**RE: Bradley Heights PUD Development Plan – Initial Review Comments  
File # AR PUD 21-00206**

The proposed project involves a PUD development plan to enable development of a vacant parcel into 168 single-family residences. Staff finds that the application is largely acceptable; however, the following technical modifications must be completed.

PUD DEVELOPMENT PLAN
PUBLIC UTILITY & FACILITY PLAN - NORTH

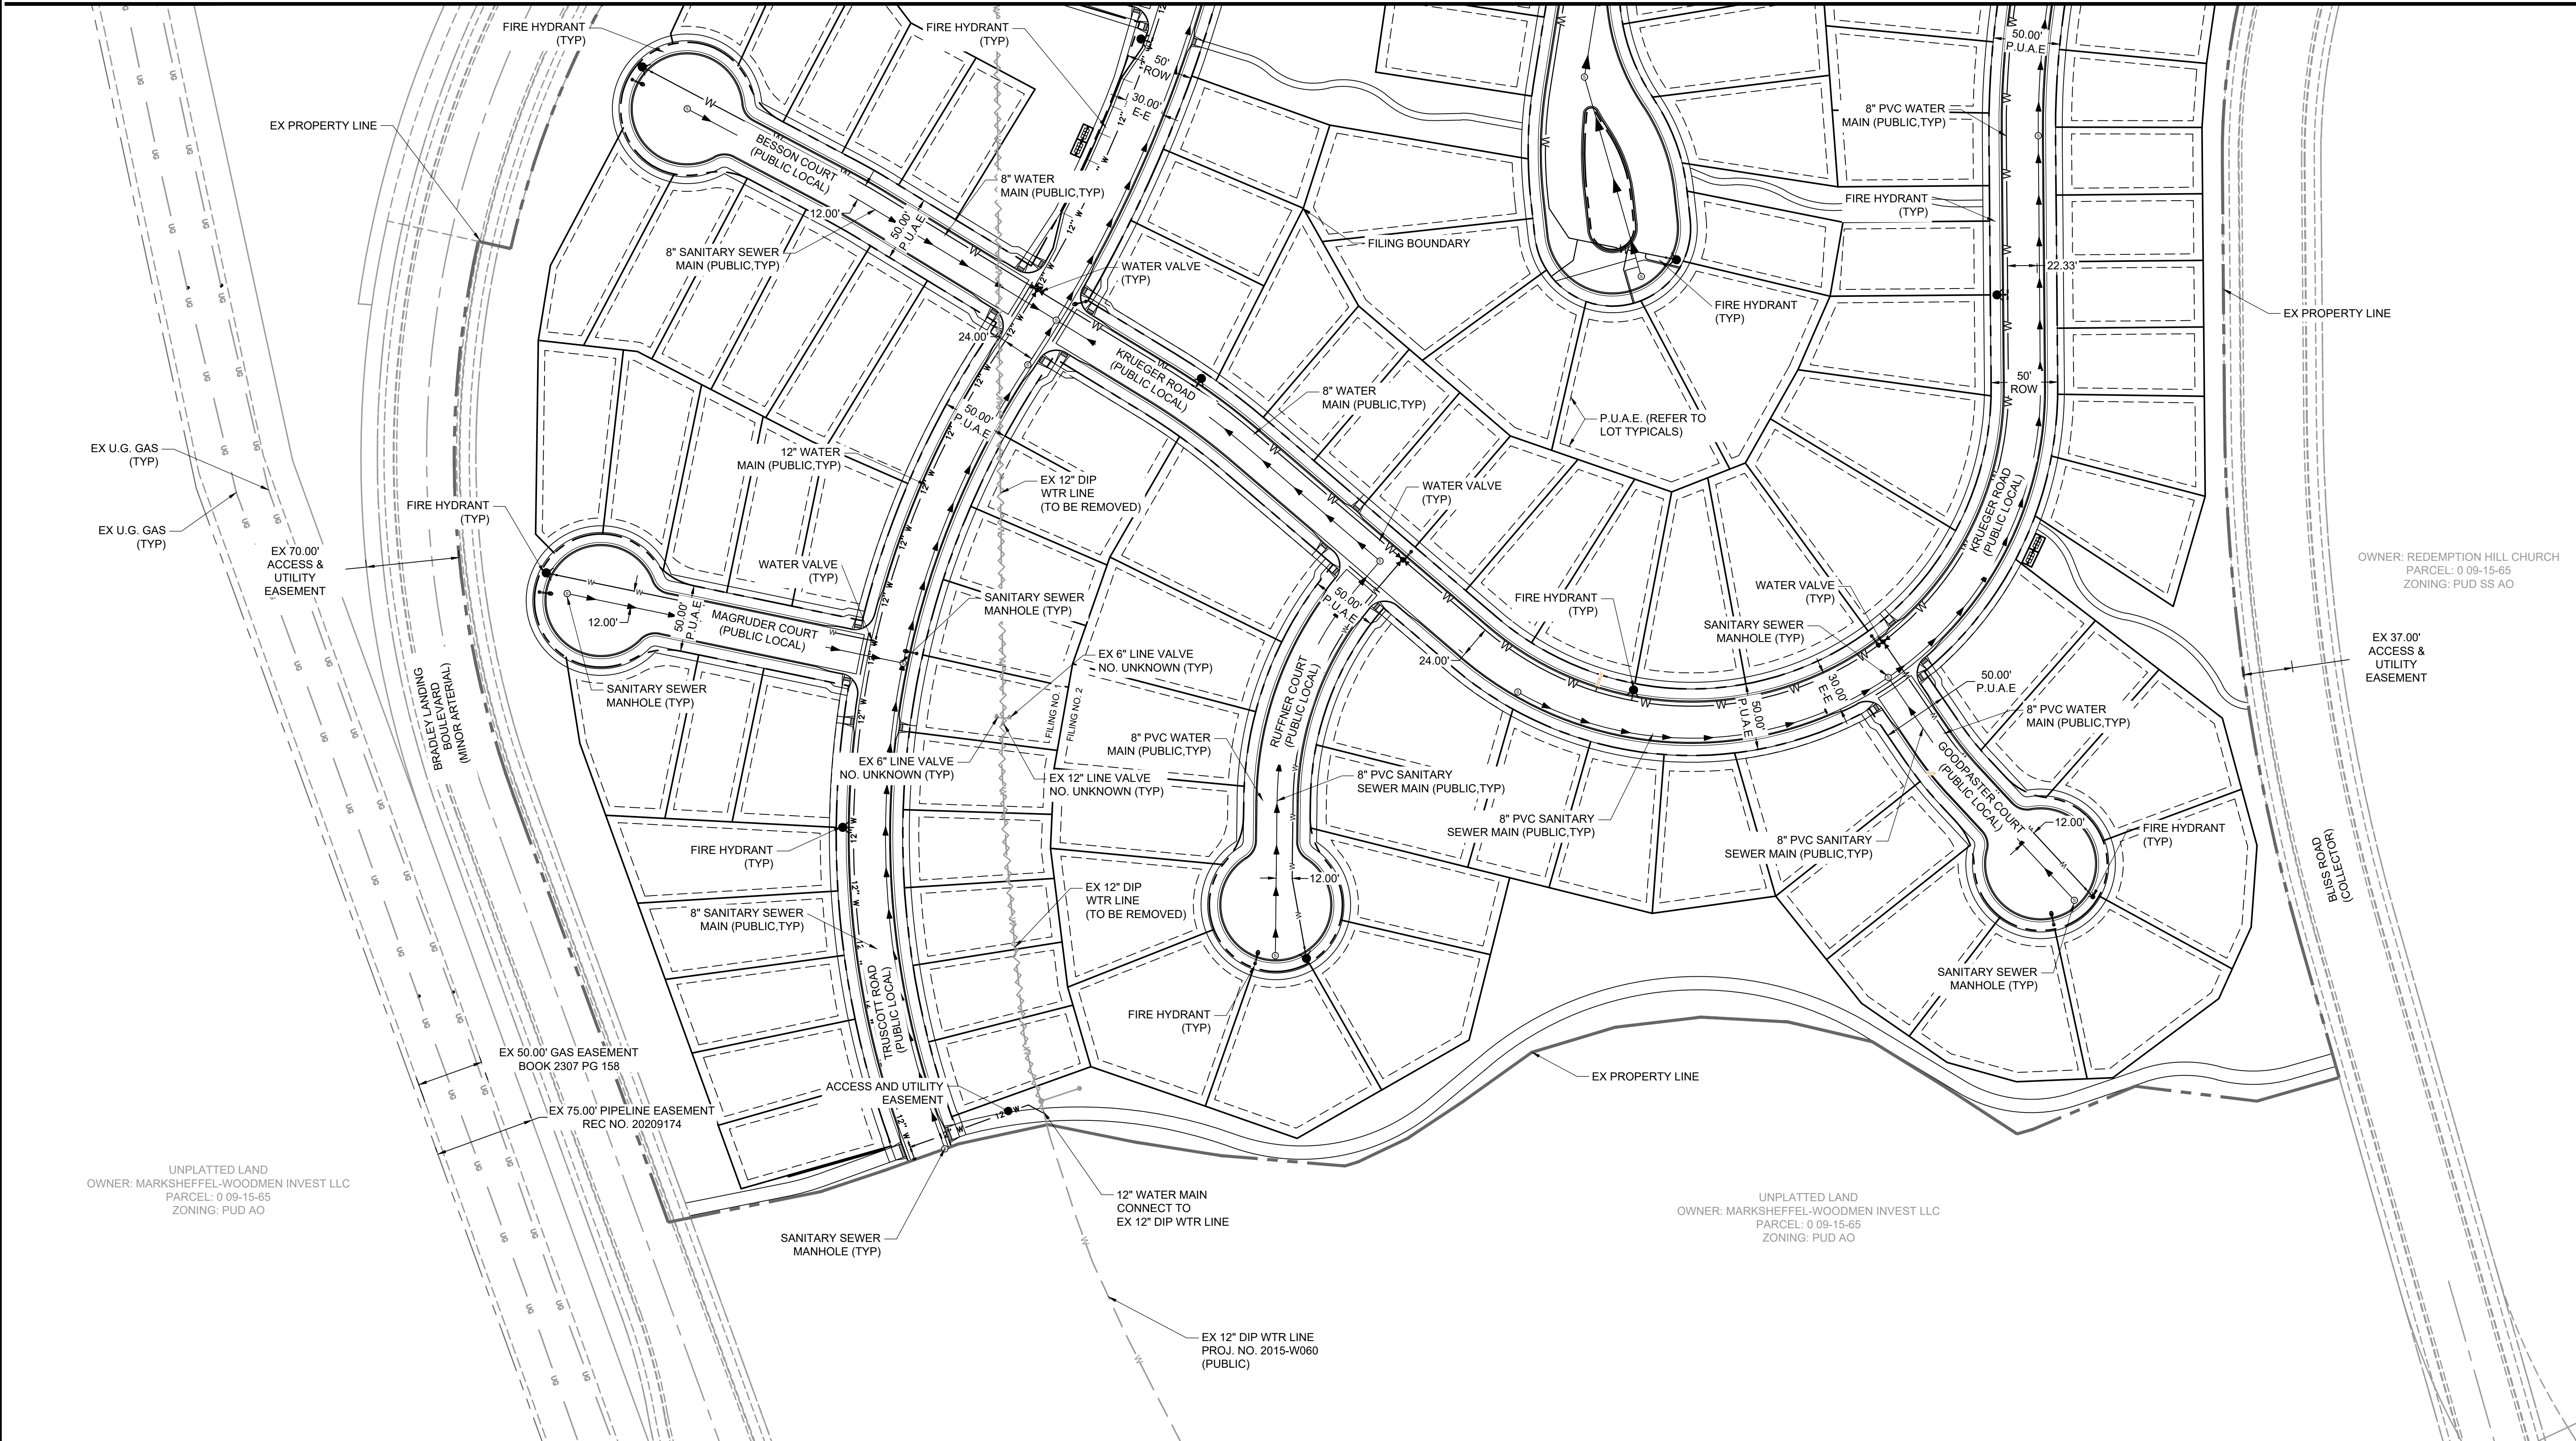
3. Please revise cross sections to reflect the new approved cross sections.
  4. Per city code water and wastewater mains must be extended to furthest extent of property. Please revise appropriately for Filing No 2 down Bliss Dr.

5. Please show and label any proposed easements to include widths. This includes front, rear and side lot widths.
  6. Please provide a typical lot layout including proposed easements and proposed service lines with proposed gas and electric meter locations.

7. Please remove any proposed 90-degree bends to reflect two-45-degree bends.
